# CITY OF PORTLAND BUILDING PERMIT

**PERMIT ID:** 2012-65516

has permission to **To construct a 24 X 32 single family house - cape with full dormer - 16 Castine Avenue**

**From:** Jonathan Rioux  
**To:** Jim Wolf  
**Date:** 1/2/2013 9:01 AM  
**Subject:** 18 Castine Ave.

ROOF FRAMING PLAN

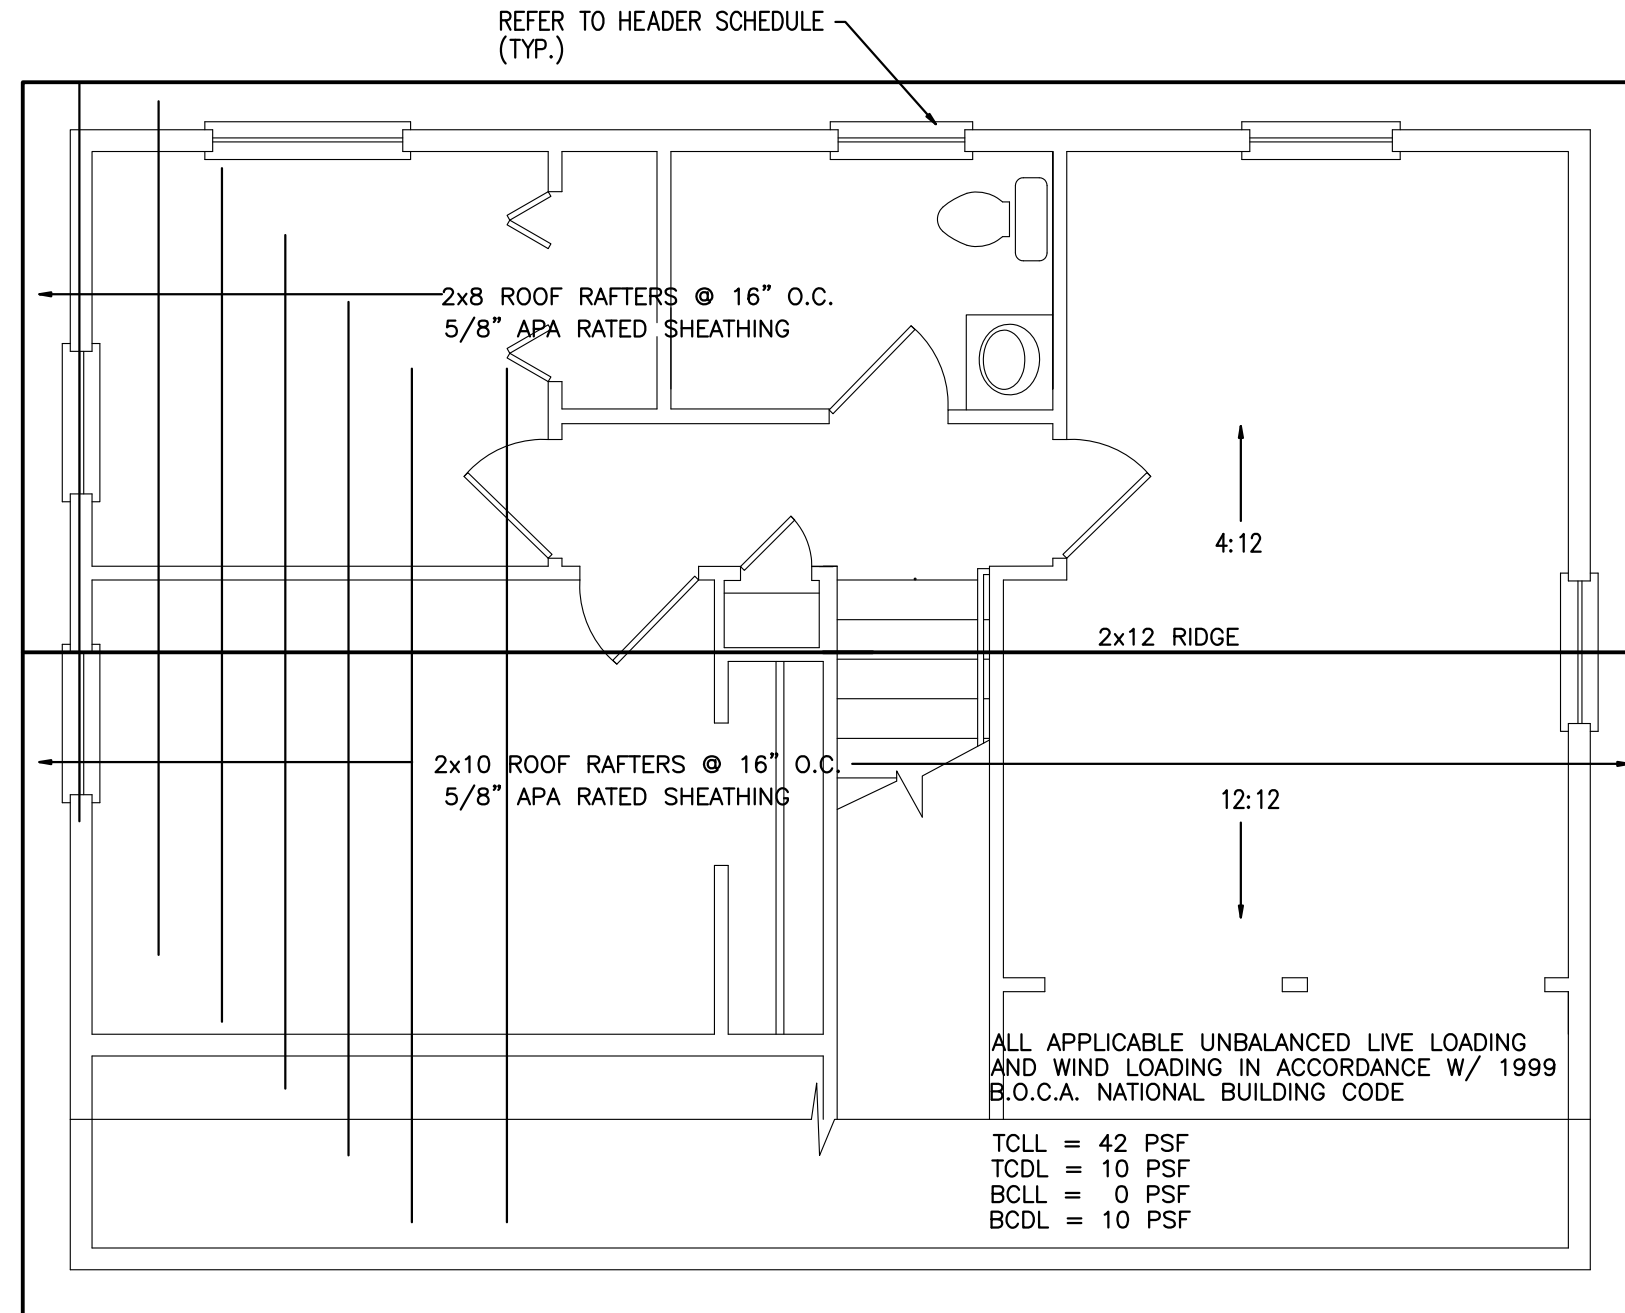
Pitch, Span, Spacing & Dimension (Table R802.5.1(1) - R 802.5.1(8)) Roof Rafter; Framing & Connections (Section R802.3 & R802.3.1)	 2x10 & 2x8 @ 24" o.c.	Plans also indicate trusses?
Sheathing; Floor, Wall and Roof (Table R503.2.1.1(1))	Floor: 3/4" / Wall: 7/16 / Roof: 5/8	okay
Fastener Schedule (Table R602.3(1) & (2))	"Per Code"	
<b>Private Garage</b> (Section R302.5) Living Space (Above or beside)?	N/A	
Table R302.6 Fire separation (Section R302.6)		
Opening Protection (Section R302.5.1)	N/A	
Emergency Escape and Rescue Openings (Section R310)		
Roof Covering (Section R905)	25 yr Fiberglass shingles	okay
Safety Glazing (Section R308)	"Temp. in 2 <sup>nd</sup> Flr. Bathroom"	
Attic Access (Section R807)	→	○
Chimney Clearances/Fire Blocking (Chap. 10)	N/A	
Header Schedule (Tables R502.5(1) & (2))	"See A1"	
Energy Efficiency IECC, 2009 R-Factors of Walls, Floors, Ceilings, Building Envelope, U-Factor Fenestration Ventilation of Space per ASRAE 62.2, 2007

A2

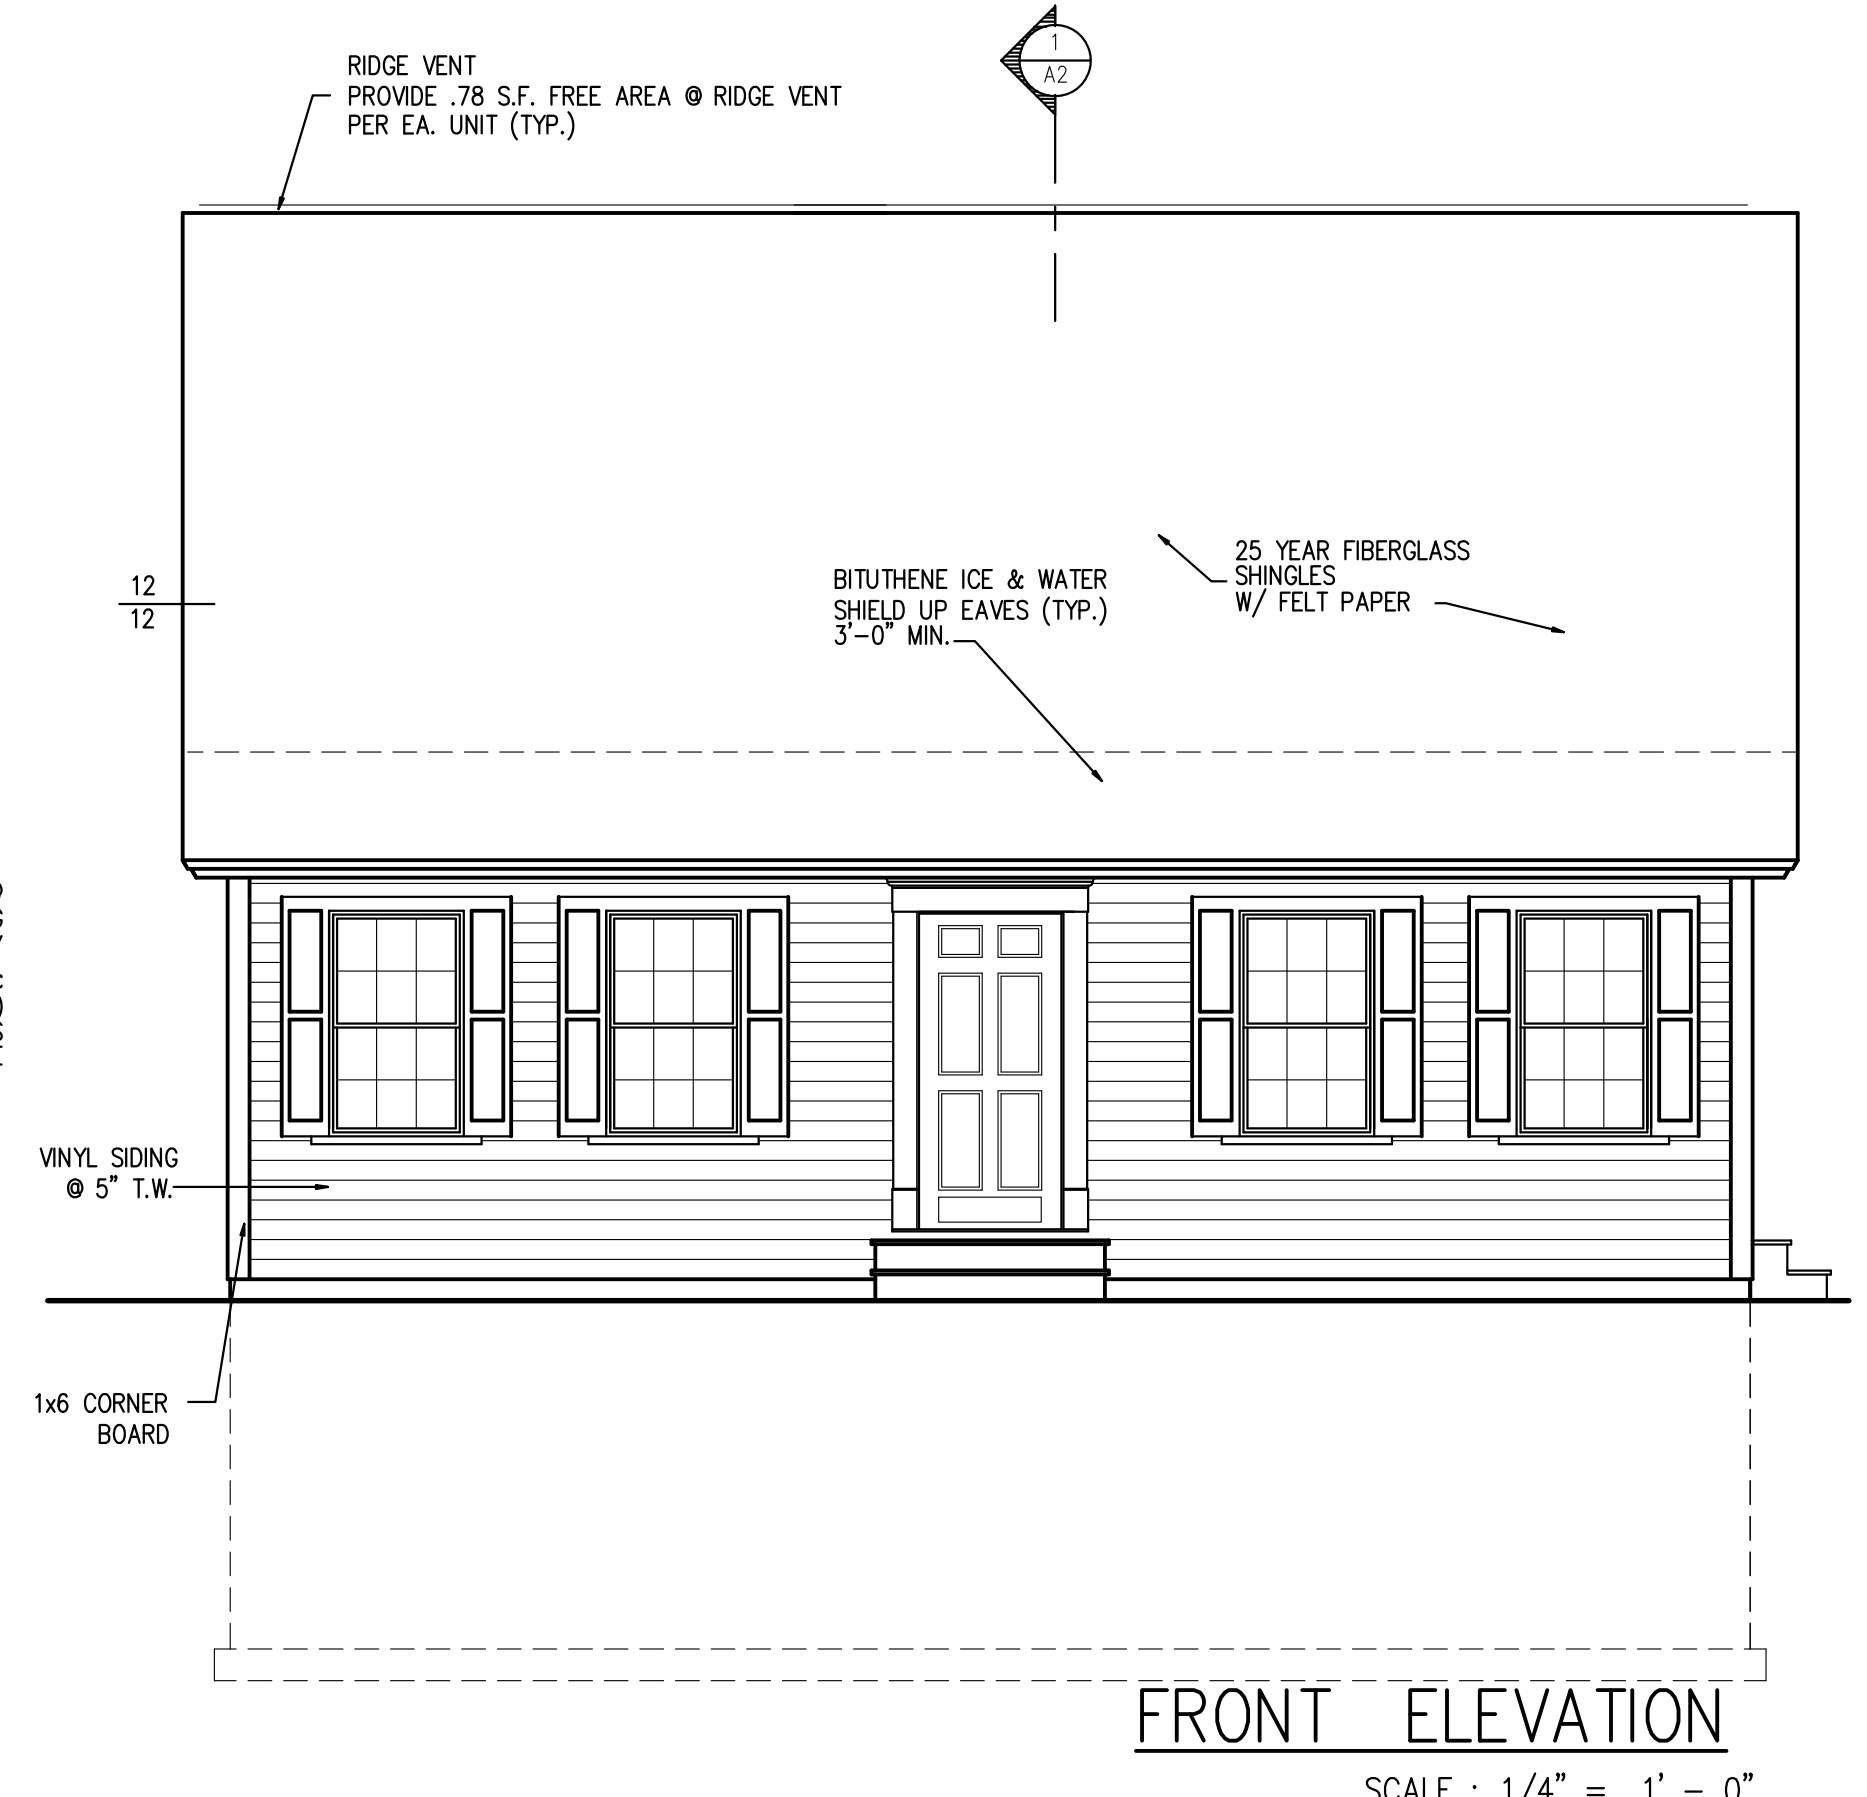
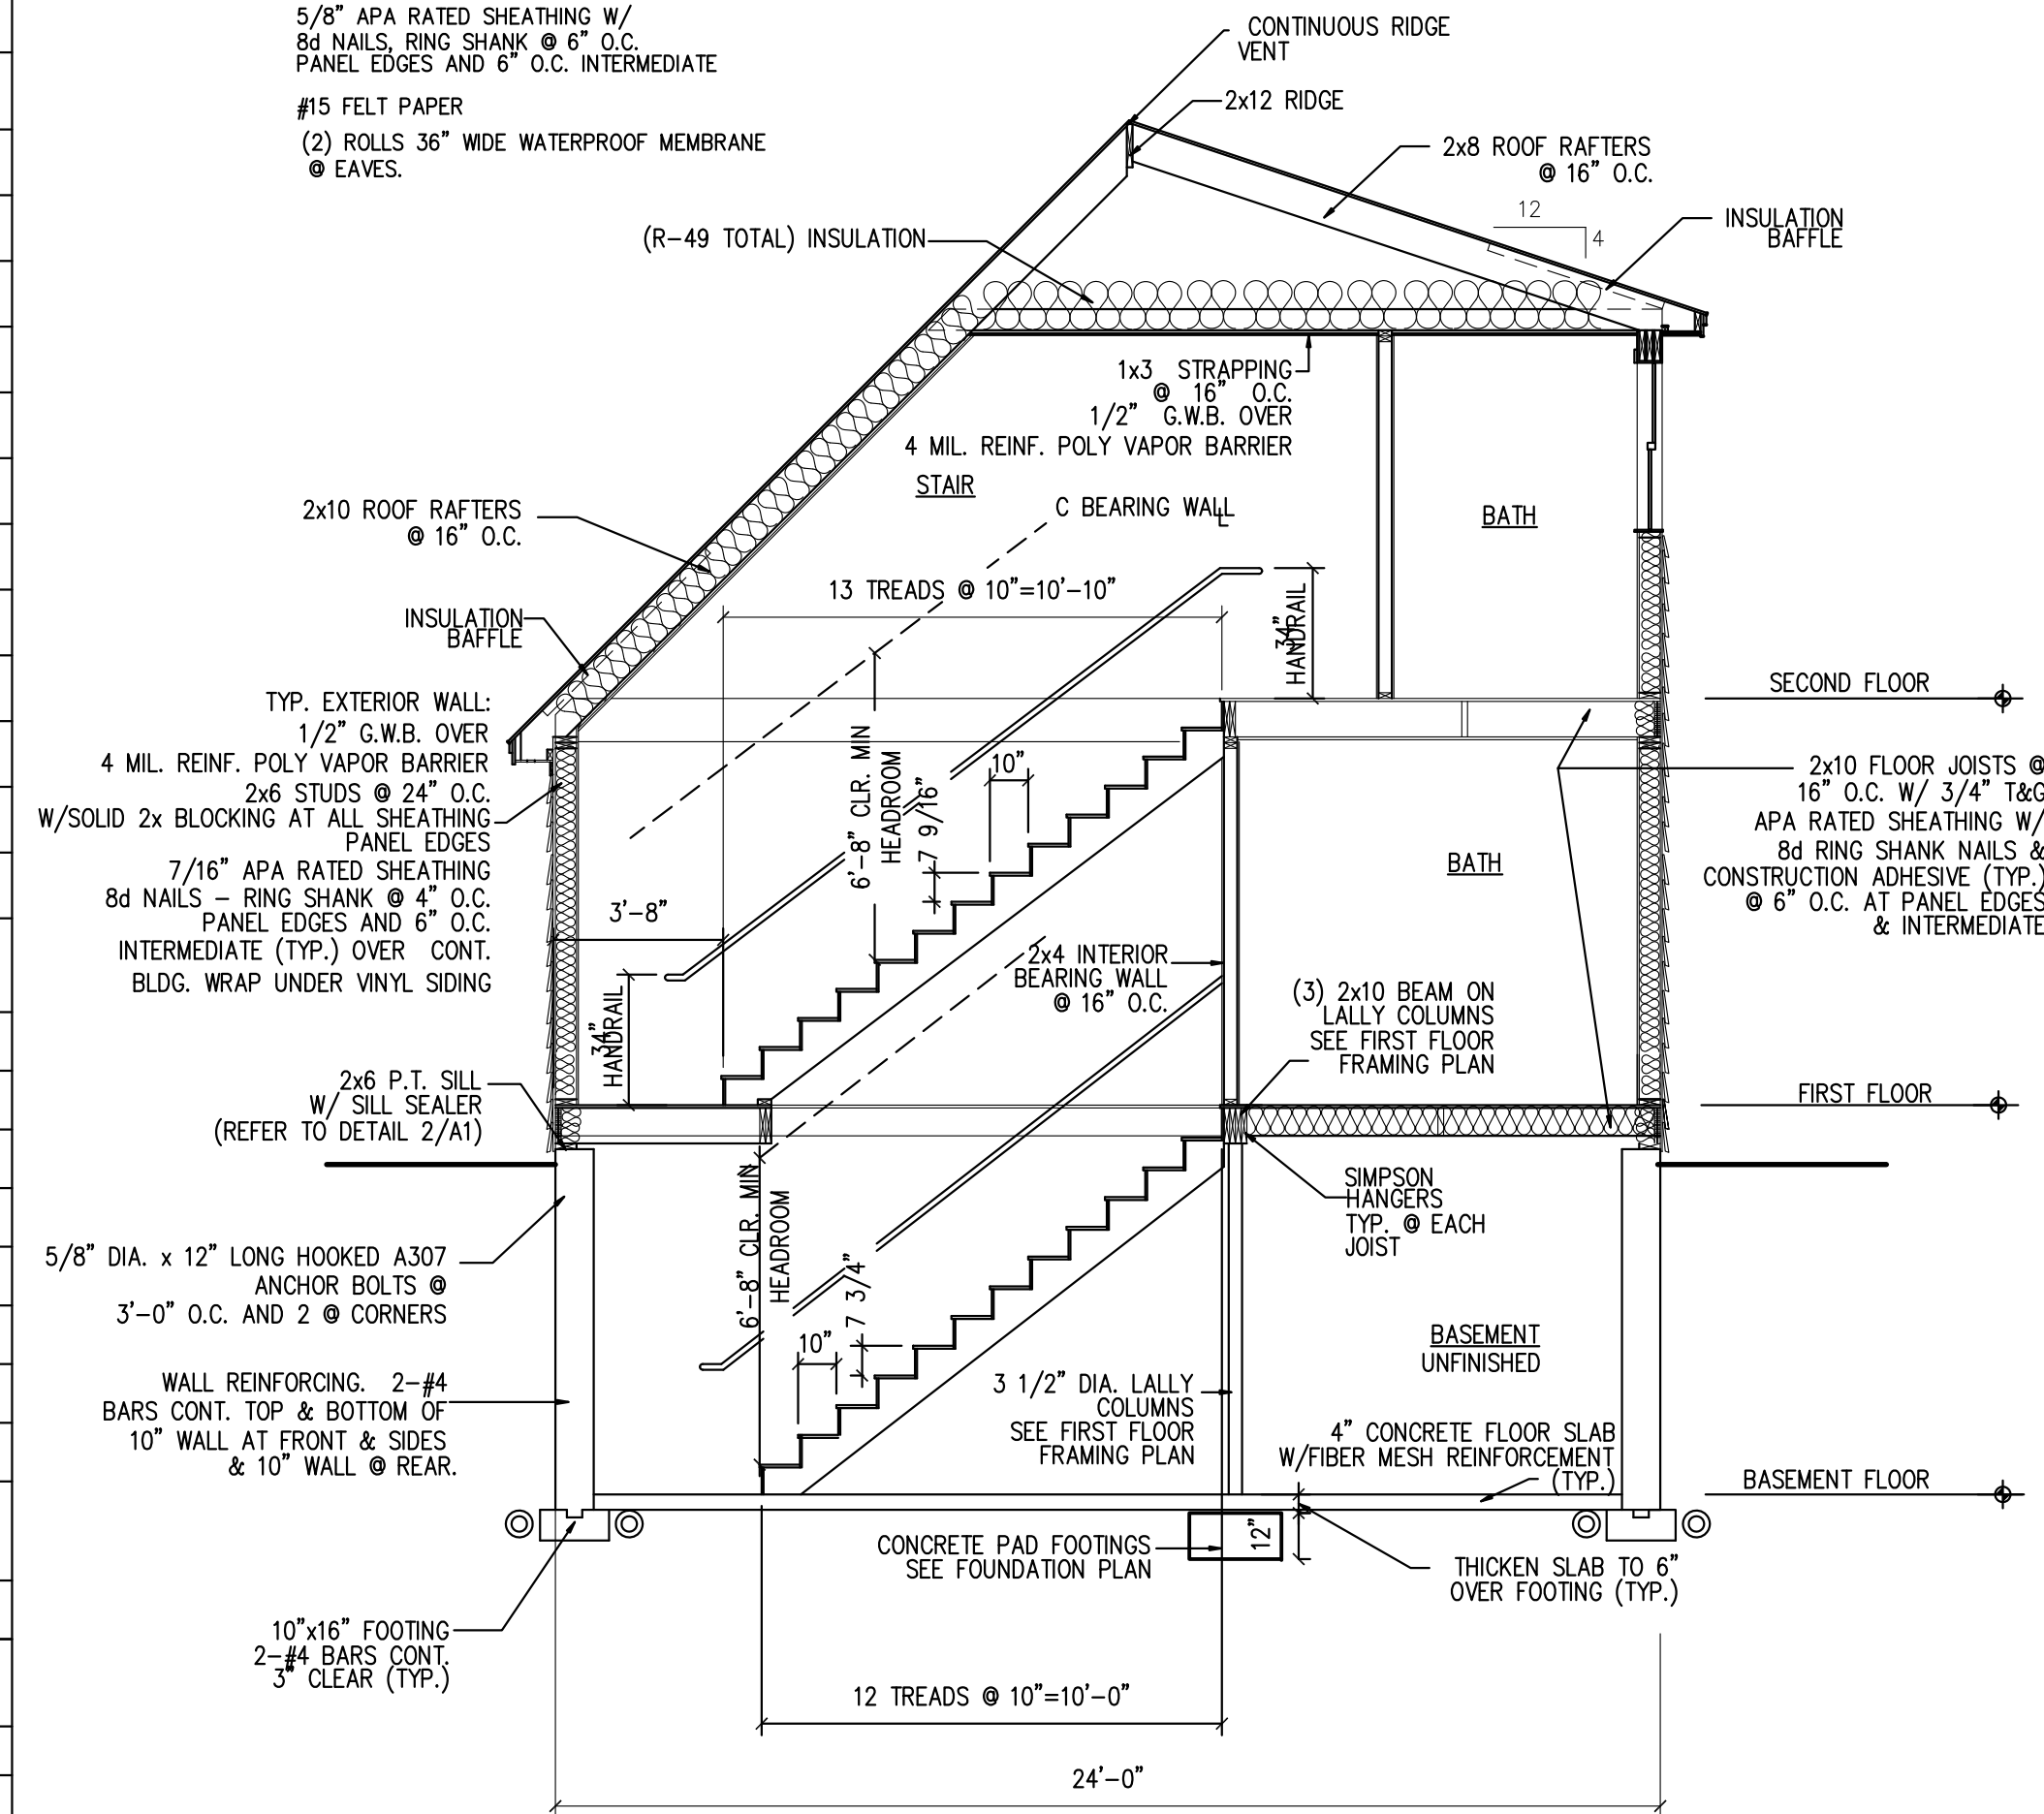
- A2 (our copy) does not show a cross section/ framing plan for a full or partial dormer.
- Is the residence going to have trusses or wood rafters?
- Is there attic access?
